DELEGATED HOUSEHOLDER DECISION

Planning permission is sought for the erection of a two storey extension to the rear.

23/912/4

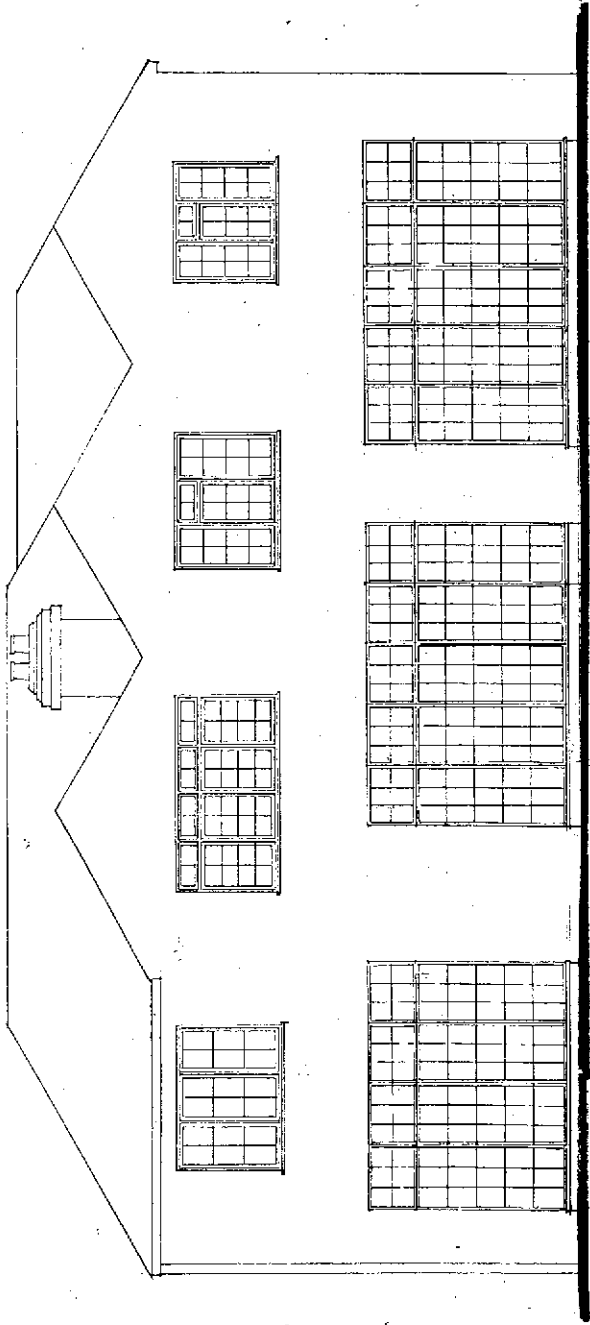
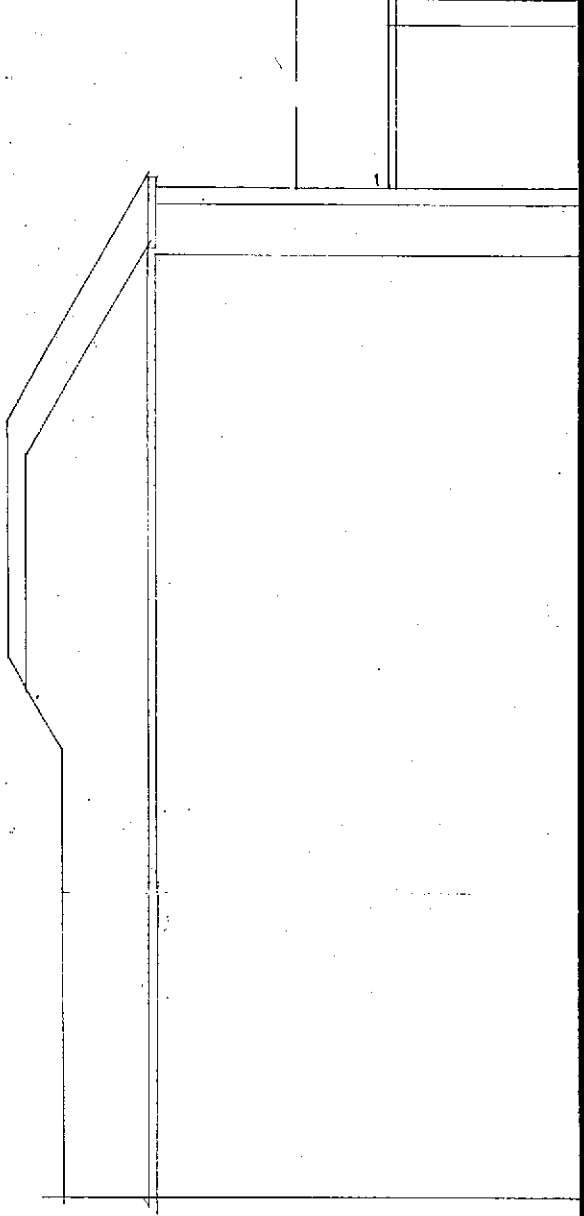
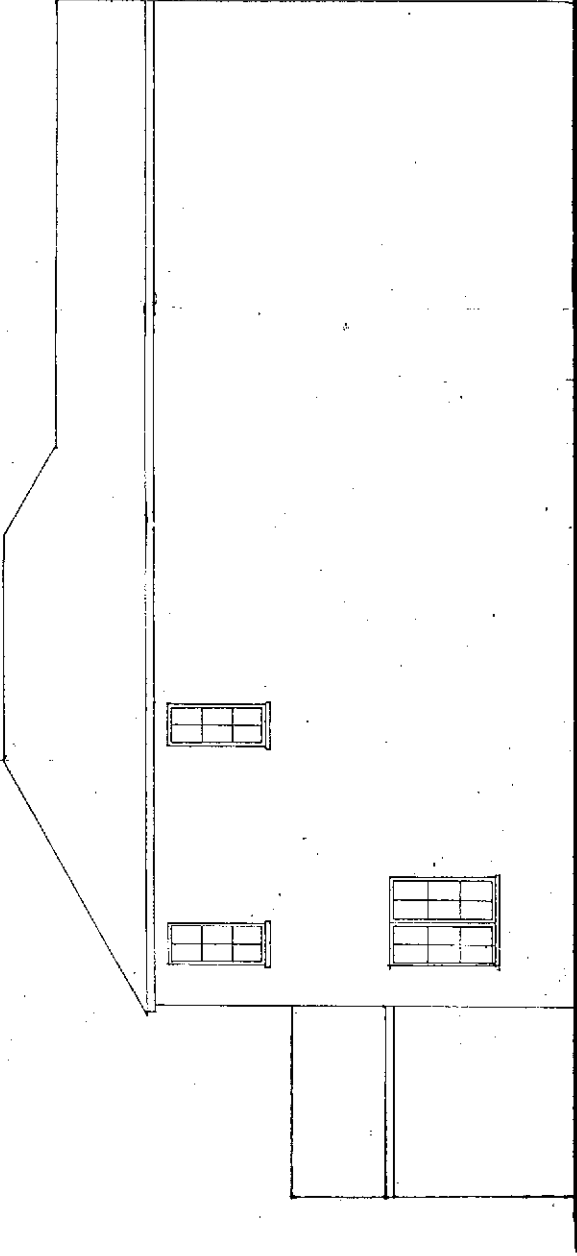
No roof design drawing has been provided currently, but the rear elevation drawing suggests that this poor design feature is being kept in what looks to be an effectively extended form.

The proposed two-storey rear extension, when viewed cumulatively with the existing extensions, would appear wholly unacceptable, bulky and disproportionate to the host dwelling. The resultant depth, and the blank facade of the side wall spanning approximately 13.5m deep would not be acceptable and would be visually imposing on the existing building and the wider area. The existing

elevation to the rear including the three-sectioned pitch roof present juxtaposition of with the main hipped roof to the front of the dwelling and constitutes poor design, and on that basis, the further expansion of this, would exacerbate this design and result in a roof form with an inappropriate, incongruous and obtrusive design, which would be totally out of keeping with the character of the existing dwelling and the appearance of the Conservation Area.

david silverman architectural consultant 70 woodland drive, watford, herts wd17 3bz mobile: 07941 306 146	SITE	
	24 Cheney Street Pinner HA5 2TE	CLIENT
Proposed		DETAIL
DATE	DRAWING NUMBER	23/912/3
SCALE	1:100	
DRAWN BY

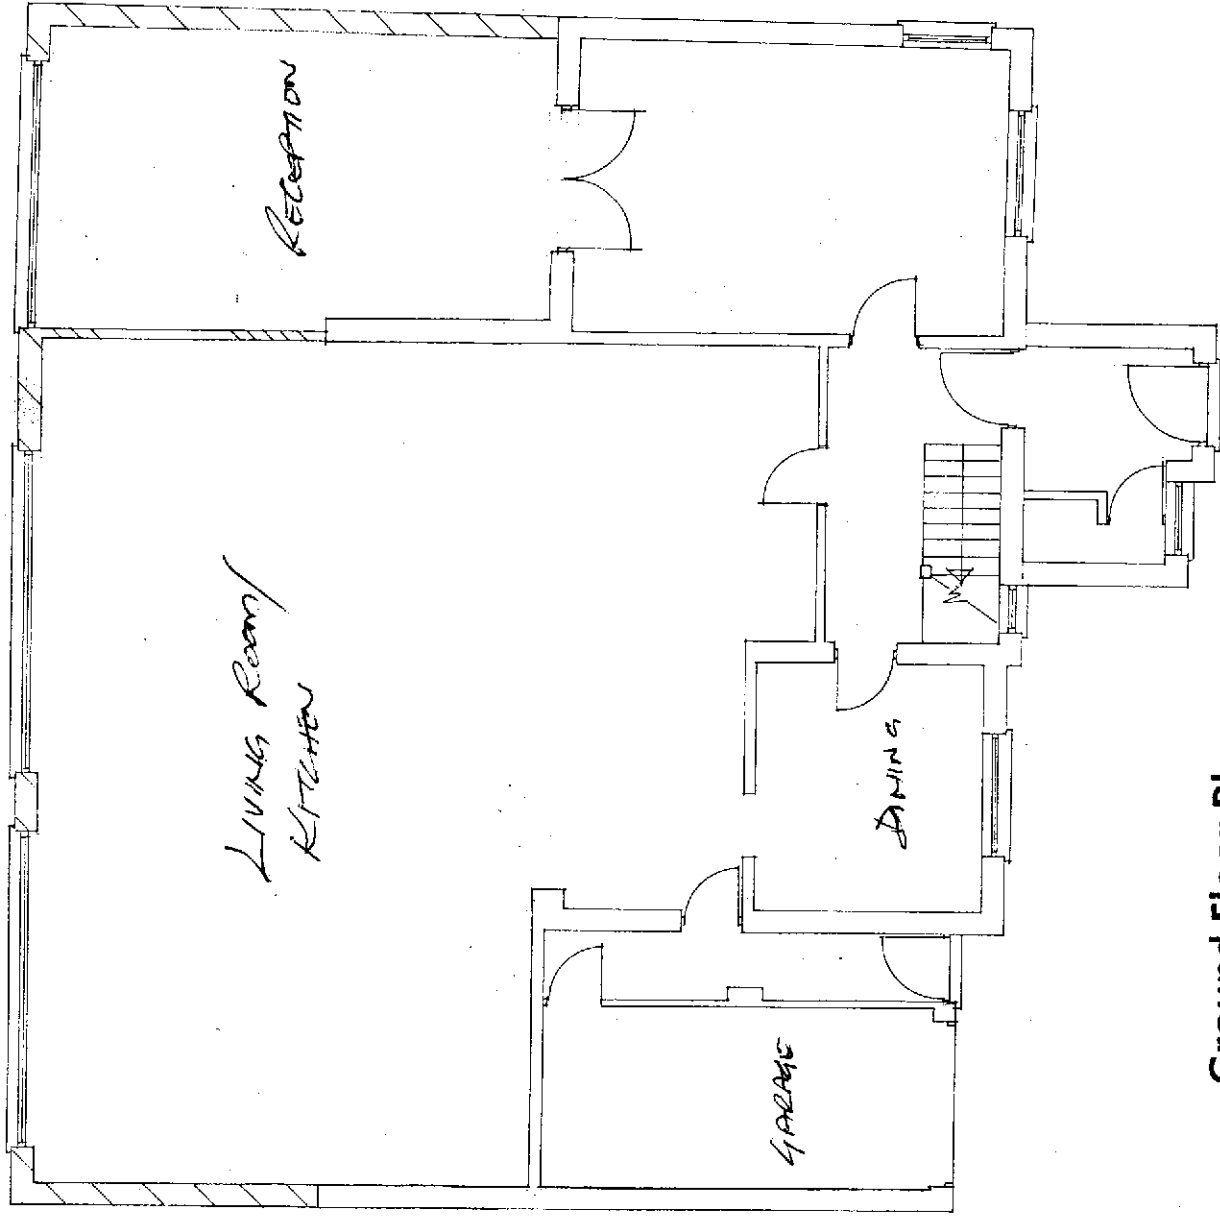
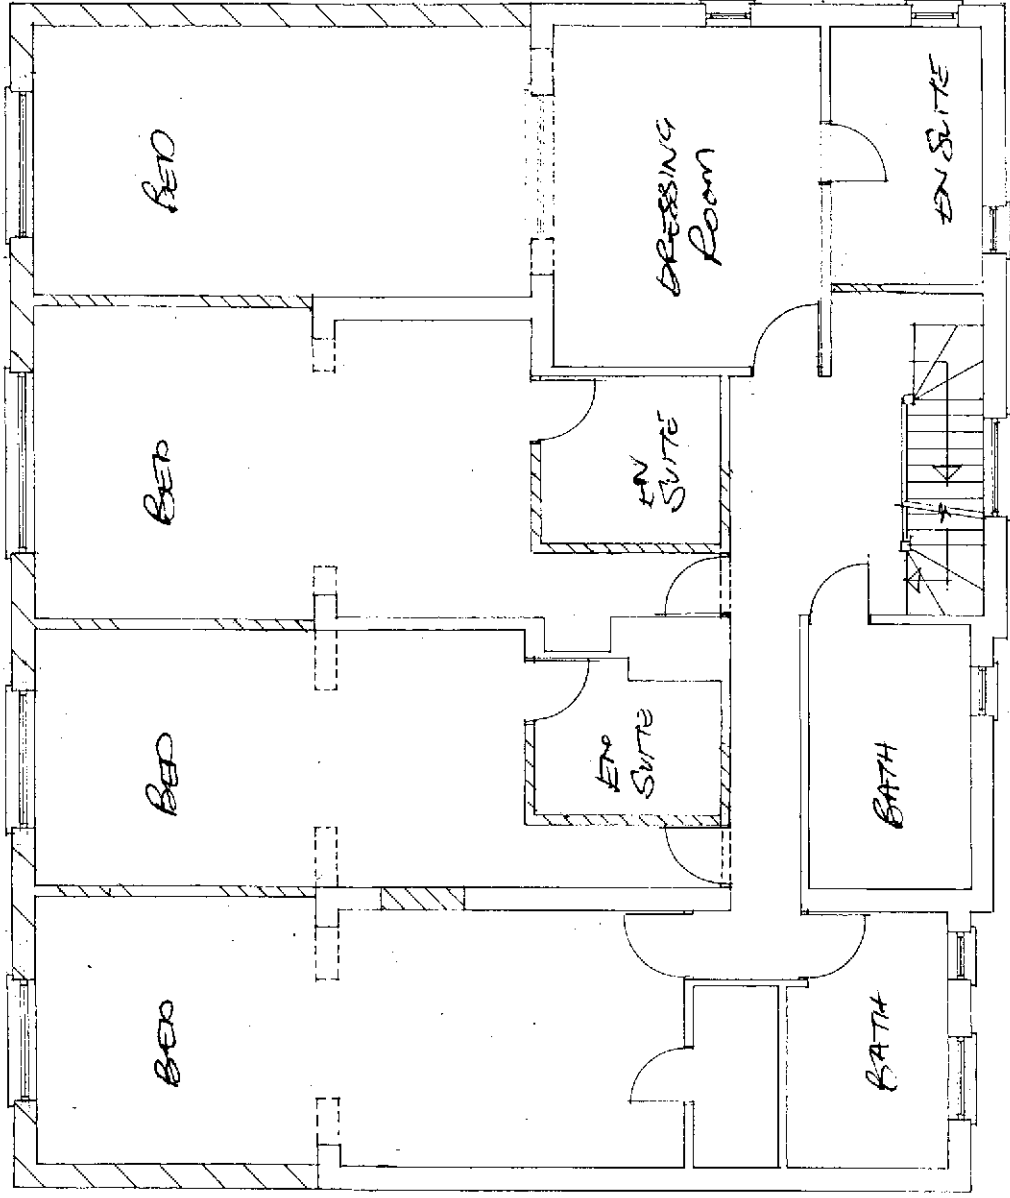
The proposed layout gives real rise for concern regarding the possibility of this property being an HMO rather than a dwelling for single family occupancy. We appear to be looking at 4 rooms already detailed as bedrooms + 3 ensembles and 2 bathrooms. The bedrooms are configured in such a way on the drawing that we could almost be looking at bed-sitting room type layouts. In addition, there are other rooms on the ground floor - one where the use is not shown + two, respectively shown as a reception and a dining room which could easily be repurposed as there is also a large living room and kitchen shown.

The existing dwelling has been historically extended to the northern side and rear at two storey level, and has a substantial width of 15.8m. The existing two-storey rear addition at the dwelling is set away from the southern edge of the original recessed rear wall by 3.9m. The proposed two-storey extension to the rear would span across the entire width, including across the remaining existing rear wall. From the original rear wall, the proposed two-storey rear extension would measure a depth of approximately 6.85m, a width of 15.8m and the proposed roof line with the three pitched roofs mirrored.

No. 26 Cheney Street is located to the north of the site and comprises a detached two storey dwelling, the neighbouring property is a locally listed building. Due to the staggered building line, the application site sits significantly in front of No. 26. The proposed two-storey rear extension located approximately 1.7m from the boundary. It would be located approximately 3m from the front elevation windows at No. 26. Due to the substantial scale, depth, height and design in such close proximity to the neighbouring property and habitable windows, it is considered that the proposal would result in unacceptable overshadowing, loss of light, loss of outlook and overbearing impact.

No. 22 Cheney Street is located to the south of the site and comprises a detached two storey dwelling. The proposed two-storey rear extension would be located 6m from the shared boundary and approximately 9.2m from the neighbouring flank wall. However, given the sheer bulk, siting and height of the extension, it would be readily visible and result in a loss of outlook and overbearing harm to the neighbouring property at No. 22.

22/2512/3A

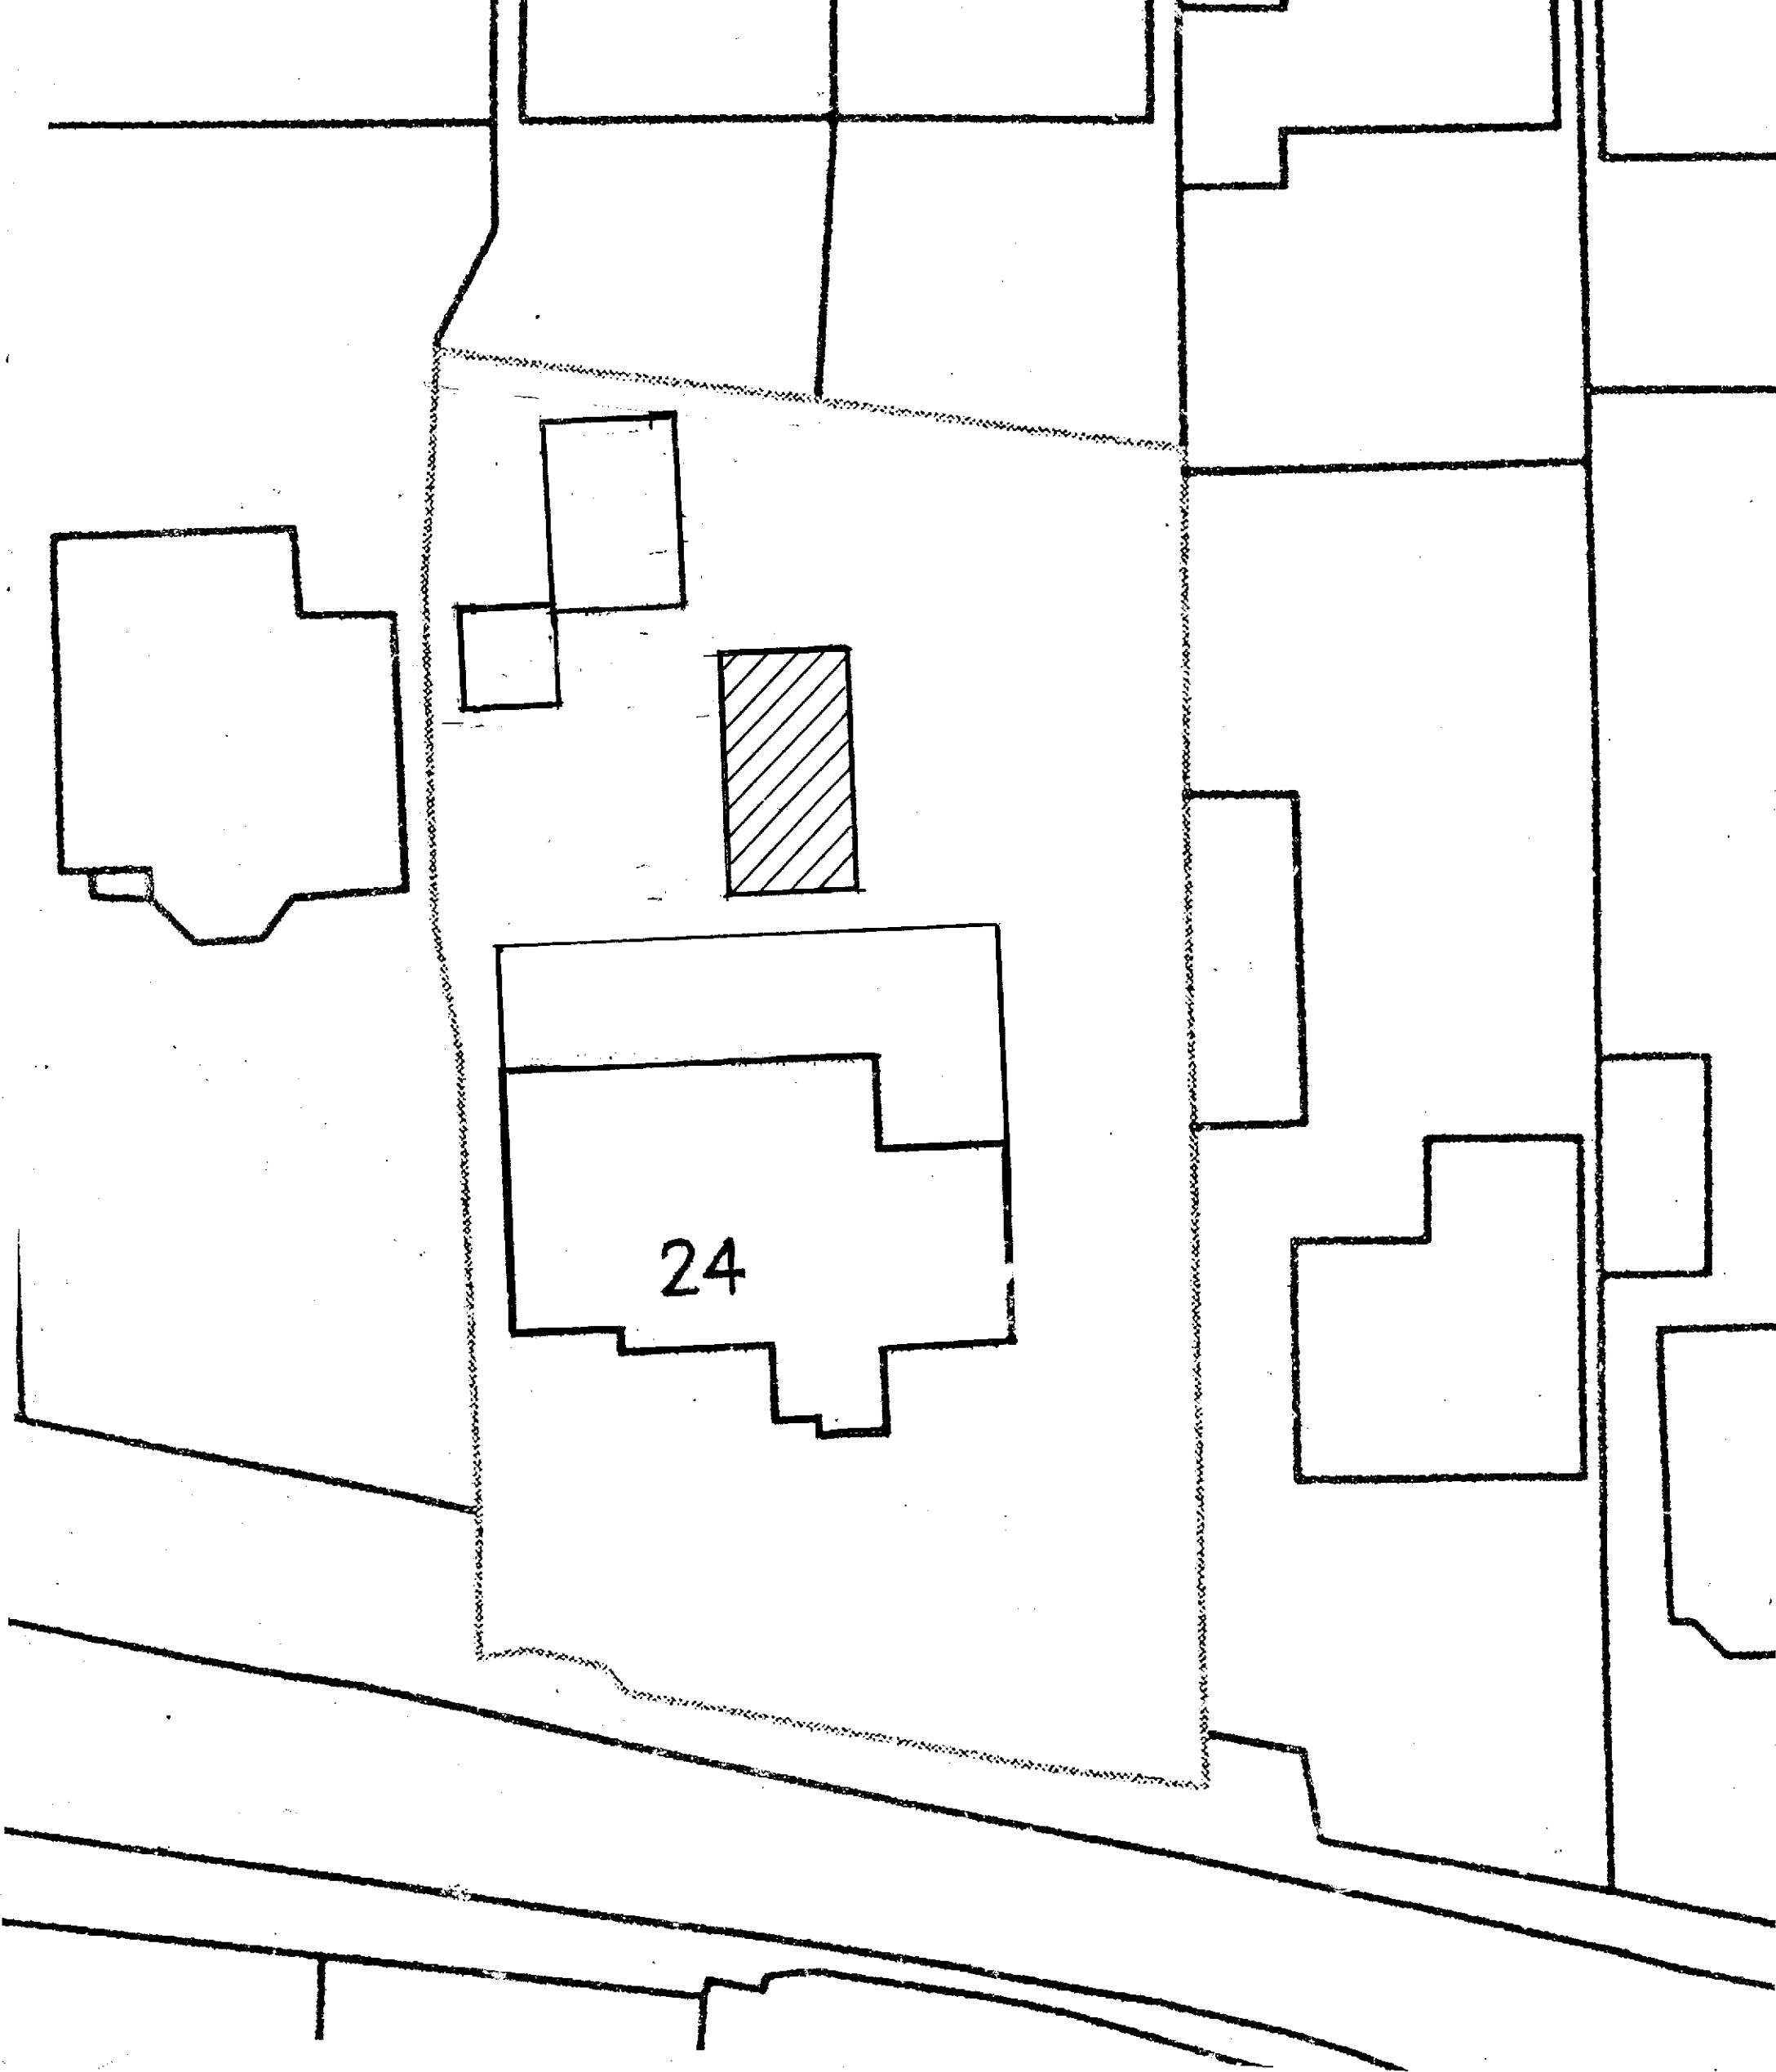
The last, approved application was for an outbuilding over a swimming pool in the rear garden (application ending 209). This is one of two existing buildings that are not shown in the current drawings, the 2nd being a large portacabin which is sited close to the back fence, separating the Eastfields gardens. I am told that this latter structure now has a wall round it, thus taking up even more space and creating an even more dominant feature. In addition, apparently there are now works in progress to build a third outbuilding. An historic ariel view is attached which shows a number of items on the site, which will almost certainly only have increased, on the basis of the information above.

Overall, these structures already cover quite a proportion of the rear garden and seriously impact on determining whether the proposed two-storey extension can be allowed. All must be shown on the application drawings.

Planning permission was approved on 07-07-2023 for the erection of a single storey outbuilding. Following a site-visit, the outbuilding is currently under construction. The outbuilding is located centrally within the rear garden, and in accordance with the approved plans, should be constructed of glazing. The proposed two-storey rear extension would be sited only 1.2m from the outbuilding under construction. The proposed extension, at such close proximity to the outbuilding would be completely unacceptable, and would have a significant adverse impact on the character and appearance of the host dwelling and the surrounding Conservation Area. When viewed cumulatively, the 1.2m gap would not be sufficient to break up the mass of the outbuilding and extension and the proposal would result in a significant volume development, with serious concerns of a future application to infill the minimal gap.

It is clear from the site visit, that an additional timber outbuilding has been erected within the rear garden. This outbuilding is not part of this planning application. A further two-storey rear extension would further develop the site, resulting in built form occupying a substantial portion of the site area. The site itself has already benefitted from a number of inappropriate, harmful alterations, including the entire site being paved over, eroding the former green garden suburb aesthetic, which is evident on surrounding sites. The proposal would result in an uncharacteristic built form within the rear garden of the site. It would be an incongruous addition to the conservation area, failing to relate to character and appearance of the surrounding area.
